## WEST SUSSEX COUNTY COUNCIL CONSULTATION

| <b>LOCATION:</b>           | 1-22 Greenfields Penn Close Middleton-on-Sea<br>PO22 7SS                                                              |
| <b>SUBJECT:</b>            | M/55/25/PL<br>Creation of 4 No. parking spaces in existing site area. This application is in CIL zone 4 (zero rated). |

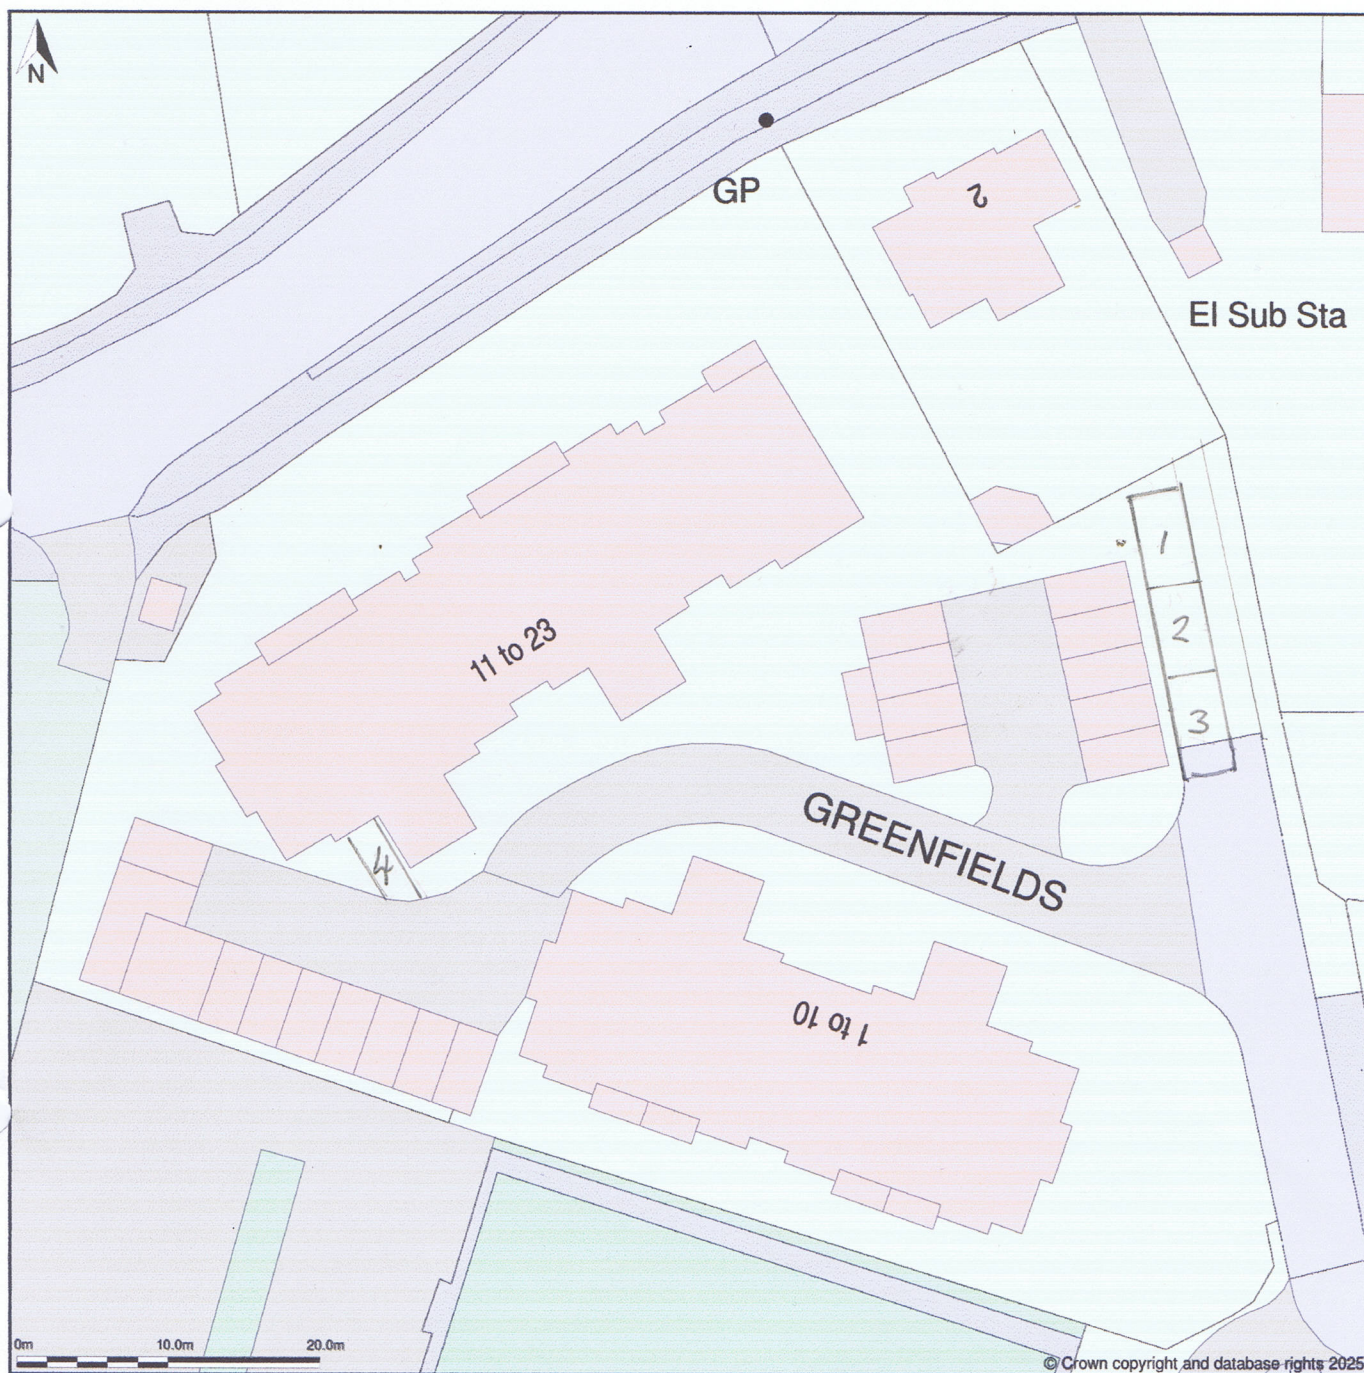
The proposed parking spaces will be located within the existing site. Three of the spaces will be situated adjacent to the existing access to 2 Elmer Road, providing parallel parking spaces. The parking spaces should meet minimum dimensions of 2 x 6m to enable vehicles to manoeuvre to and from the spaces.

The proposed 4<sup>th</sup> space will be a bay space to the south west of the existing building (11-23 Greenfields). This space should be 2.4 x 4.8m.

There appears to be sufficient space on site for vehicles to turn on site and exit onto the public highway in a forward gear. The LHA would not raise any highway safety or capacity concerns to the proposal.
